Application for Planning Permission for Works or Extension to a Dwelling

Development: Rear extension and porch
Location: 1 Manor Close East Preston BN16 1JF

Proposed Block Plan 1:500

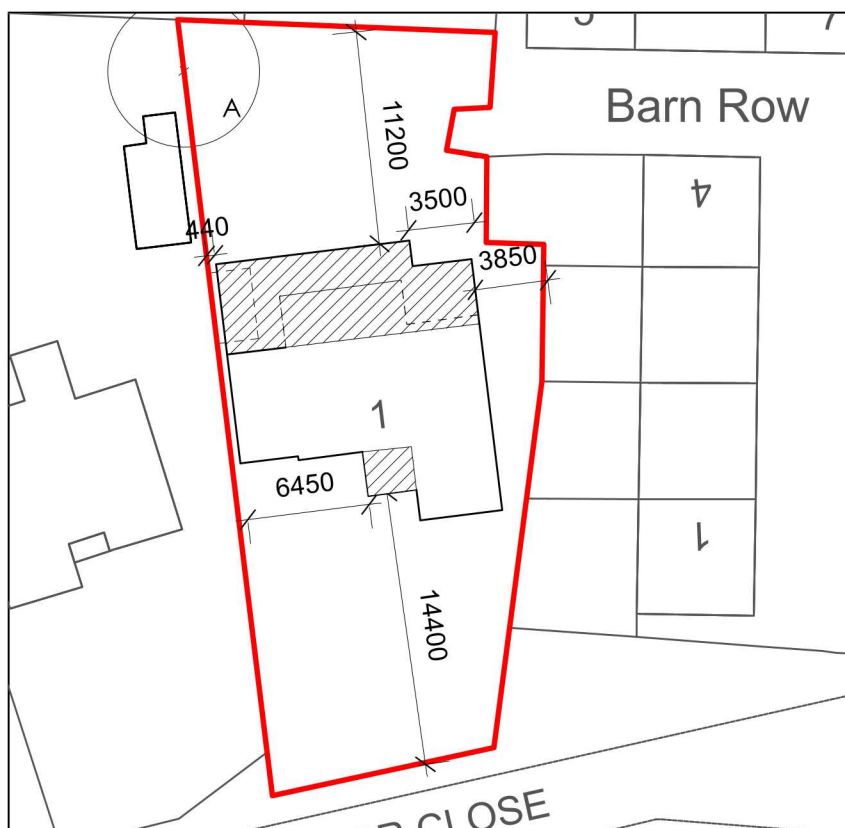
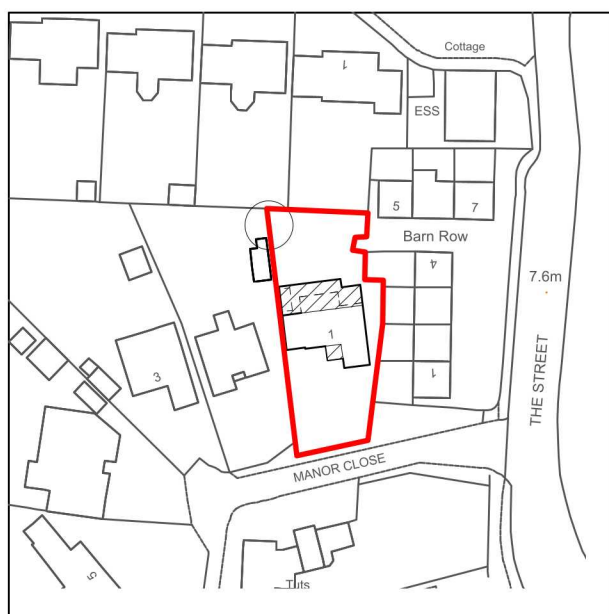
Block Plan

You are required to have dimensions from the proposed extension(s) to all site boundaries. Please amend.
